Our Ref: LU/337/19/DOC

Town & Country Planning Act 1990 (as amended)
Town and Country Planning (Development Management Procedure) (England) Order 2015
Application for approval of details reserved by conditions imposed on planning permission
LU/205/16/PL relating to conditions 6 & 12 - soakaway design alternative & soakaway design
calculations
CM Wood Body Repair Centre Linden Park Littlehampton BN17 7BJ

Arun District Council have decided to **REFUSE details reserved by condition for the following reasons:**

DRAWING TITLE
SOAKAWAY DESIGN ALTERNATIVE TO PERMEABLE PAVED INFILTRATION SYSTEM

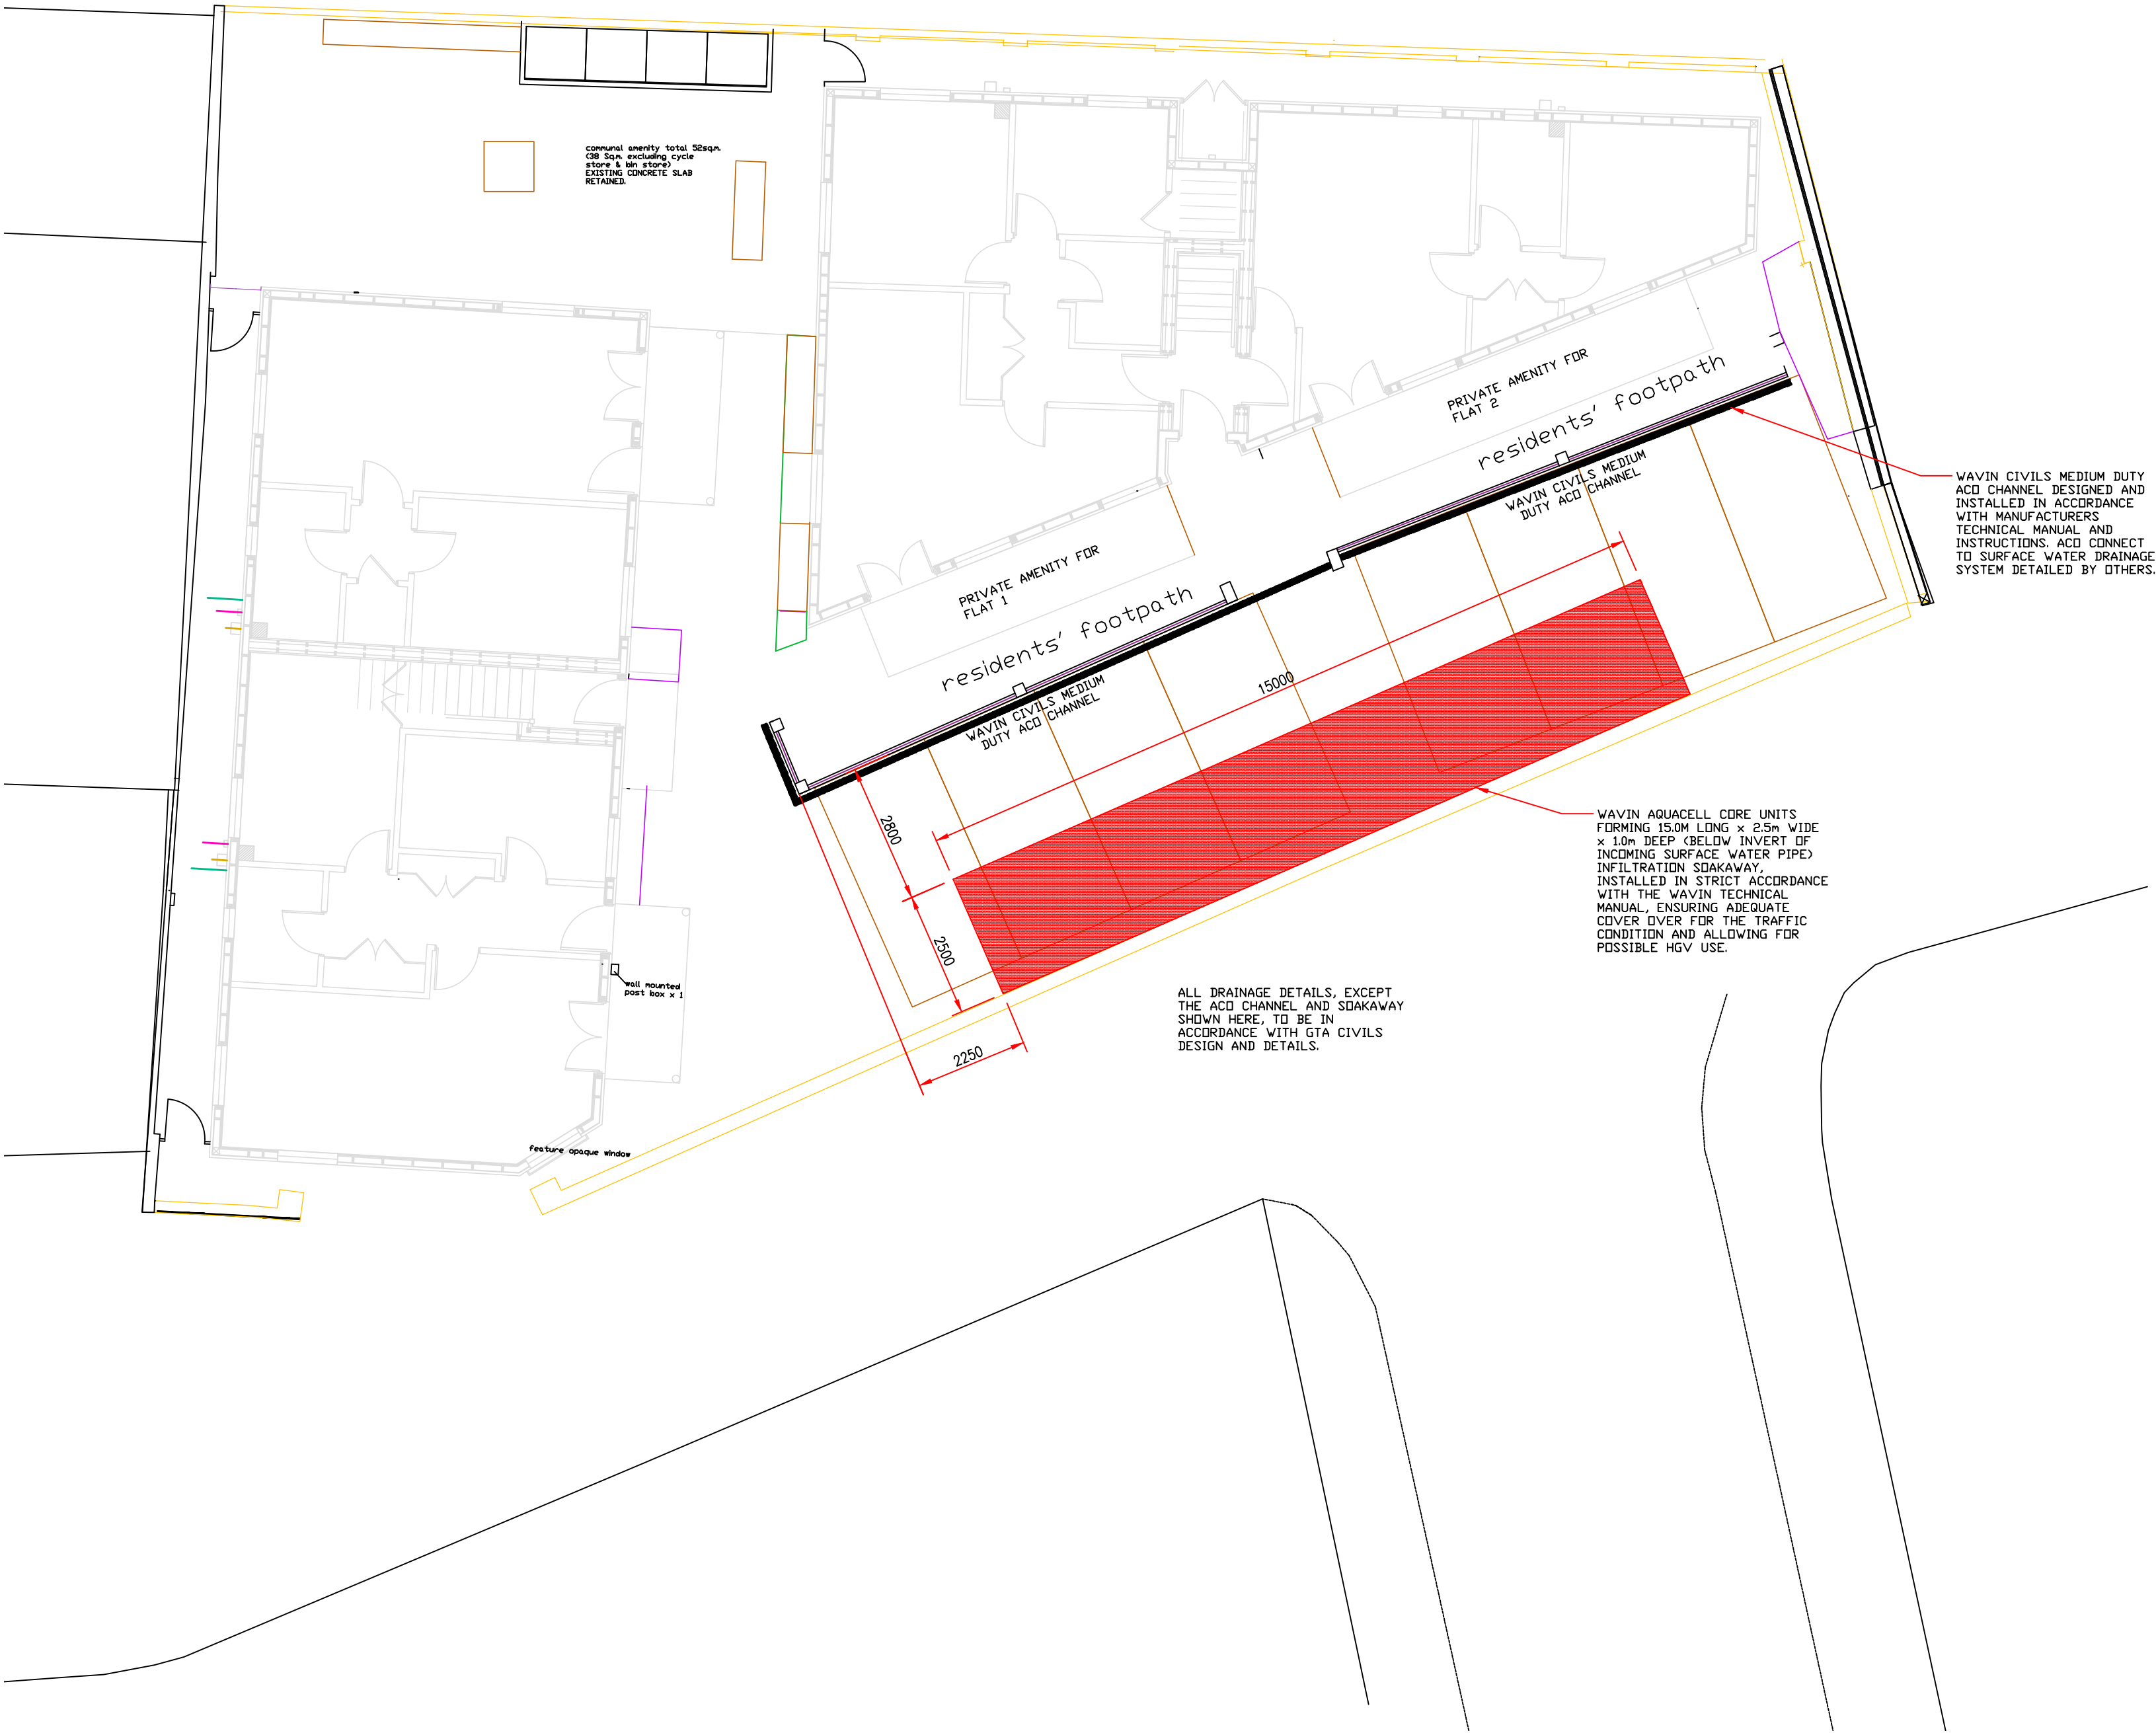
1. The proposed soakaway is 1.25m deep, with no information given as to the cover depth, although MH1 invert level is 0.5m bgl so it is safe to assume that the base of the proposed soakaway will be at least 1.7m bgl. It seems that the testing does not reflect the depth of the infiltration structure. Please recomplete infiltration testing in January-March in accordance with BRE365 to the appropriate depth of the proposed soakaway. This should be used to calculate a more accurate infiltration rate to inform the design.
2. Drawing details for the soakaway and ACO channel require cross section and the addition of the invert levels of the pipes entering the soakaway and the soakaway invert level and/or the level of the top of the soakaway.
3. Please include details of pipe diameters and materials..

4. Please add 40% allowance for climate change. This is still set to 30% however there is more than enough capacity to compensate (on basis of infiltration rate which will change).
